From: Paul Cann
Sent: 15 January 2018 15:49
To: Planning.Responses
Cc: 'Ward, Stuart'
Subject: RE: Planning Consultation on EG/107/17/DOC

APPLICATION **EG/107/17/DOC**
NO:

Registered: 21-DEC-17
Site Address: 97 Barnham Road Eastergate PO22 0EQ

Description of Works: Application for approval of details reserved by condition imposed under planning application EG/38/15/PL relating to condition No. 3 - Surface water drainage

Number
S17-03-01 E

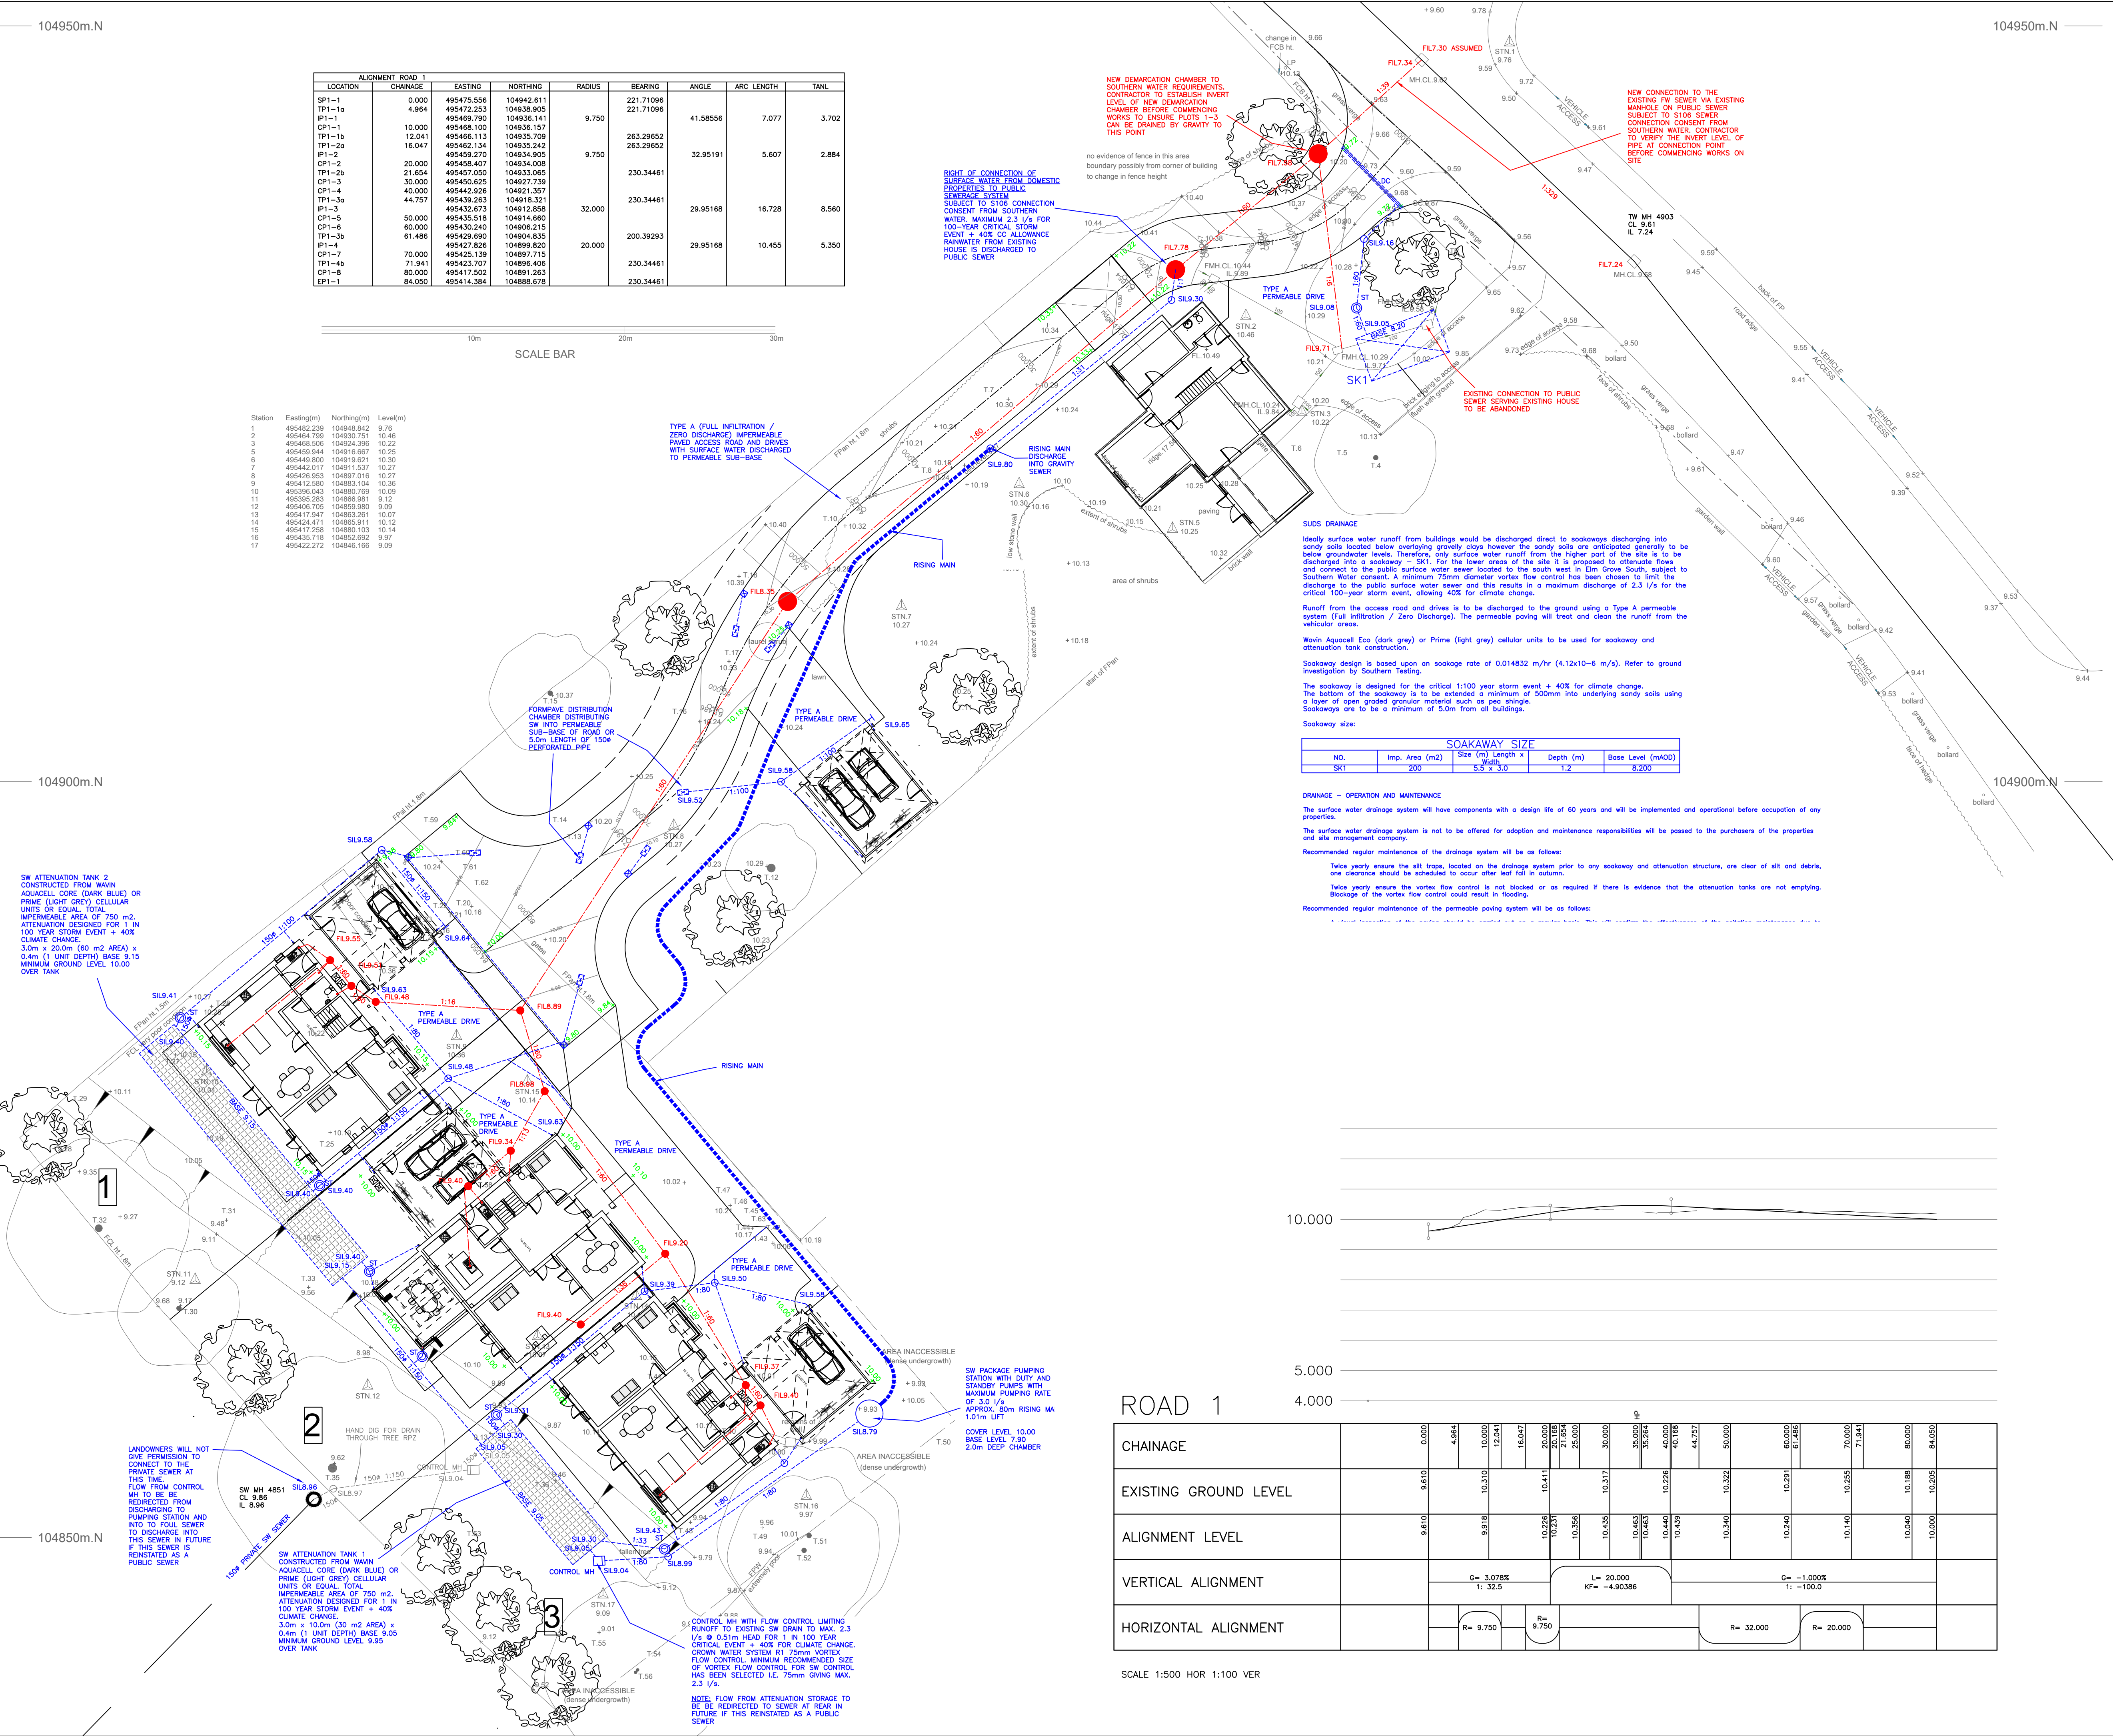
1. Provide full construction details of the package pumping station, including alarm arrangements in case of malfunction.
2. Specify rising main details (diameter/material/bedding) including thrust blocks.
3. The pump rate (note by pumping station) stipulates a max. flow rate of 3 l/s which is greater than the flow rate of 2.3 l/s required by Southern Water. Please provide confirmation from Southern Water that this is acceptable.
4. The final pipe before discharge to the foul manhole in the access road is proposed at a gradient of 1 in 1 which is too steep and will have a negative effect on foul flows within the sewer. Specify an external backdrop with soffit to soffit connection (with Southern Waters agreement).
5. The pumping station, etc will need to be maintained by the management company/residents.
